WEST SUSSEX COUNTY COUNCIL CONSULTATION

TO:	Arun District Council FAO: Simon Davis
FROM:	WSCC - Highways Authority
DATE:	20 August 2019
LOCATION:	Site 6, Chichester Road, North Bersted
SUBJECT:	BE/84/19/PL Erection of 7 No. dwellings (2 No. 2 bed & 5 No. 3 bed) with associated parking & landscaping.
RECOMMENDATION:	No Objection

DRAWING TITLE
SITE LAYOUT - PHASE 4c

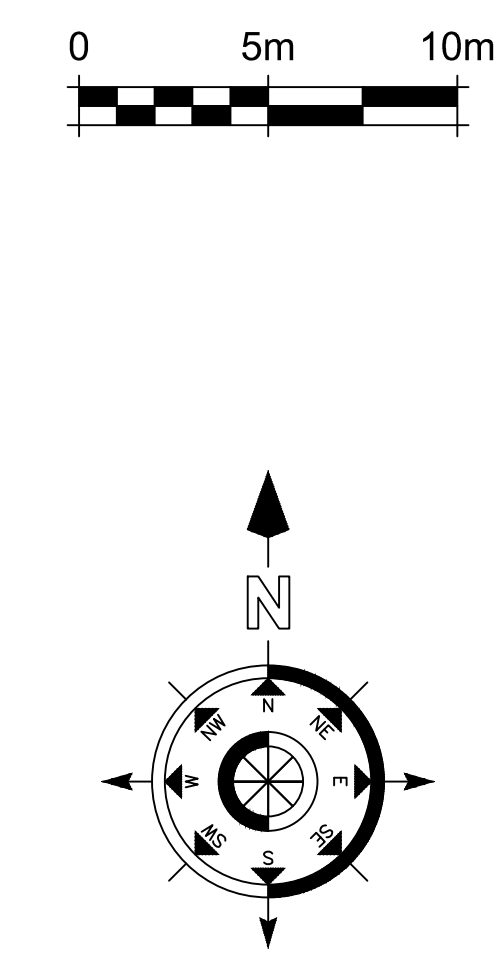
There appears to be 2 x allocated spaces per dwelling, in the form of car barns, garages and external spaces. On this basis the WSCC Parking Demand Calculator envisions a total demand for 20 x spaces, to include 6 x unallocated/visitor parking spaces. Two of the parking spaces for plot 338c have not been included within the red edge, the Local Planning Authority (LPA) may wish to ask for an amended red edge plan. 3 x visitor spaces have been included, whilst this is a shortfall in 3 x spaces the LHA are mindful of the accessible location in respect to utilising modes of transport other than the private car. Furthermore, there is visitor parking across the wider site and the LHA could not raise highway safety grounds to resist the application on this shortfall of 3 x spaces.

No part of the development shall be first occupied until the car parking has been constructed in accordance with the approved site plan. These spaces shall thereafter be retained at all times for their designated purpose.
